2 November 2017

Your Reference: DA 165-7-2005 MOD 1

**Re: Haerses Road Sand Quarry – Modification 1 (DA 165-7-2005 MOD 1) -
Supplementary Response to Submission**

Thank you for the opportunity to provide advice on the Supplementary Response to Submissions (RTS) for the modification to the Haerses Road Sand Quarry (DA 165-7-2005 MOD 1). This is a response from the NSW Department of Planning & Environment – Division of Resources & Geoscience, Geological Survey of New South Wales (GSNSW).

Figure 6: Location of Haerses Road offset area

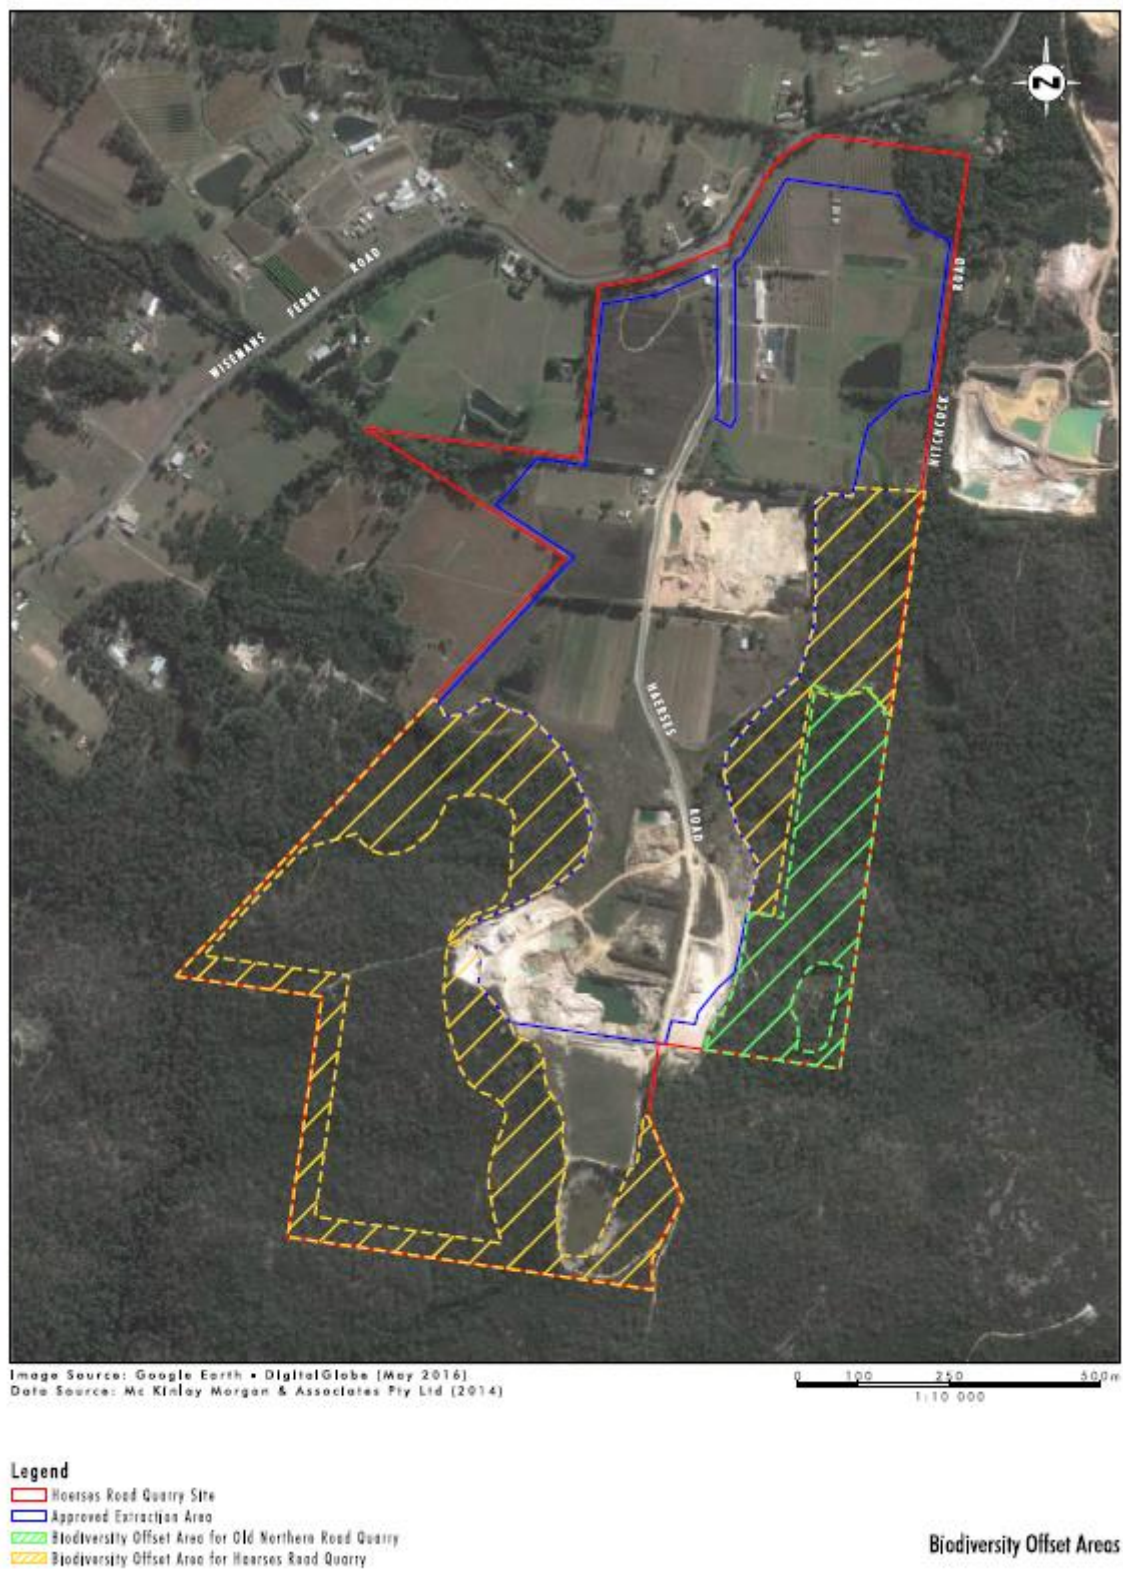
GSNSW has reviewed the Supplementary RTS and has no resource sterilisation concerns in relation to the Porter Road BioBank Site. However, the proposed Haerses Road Biobank site, which covers approximately 28.18 ha of the development site, will result in sterilisation of known sand resources.
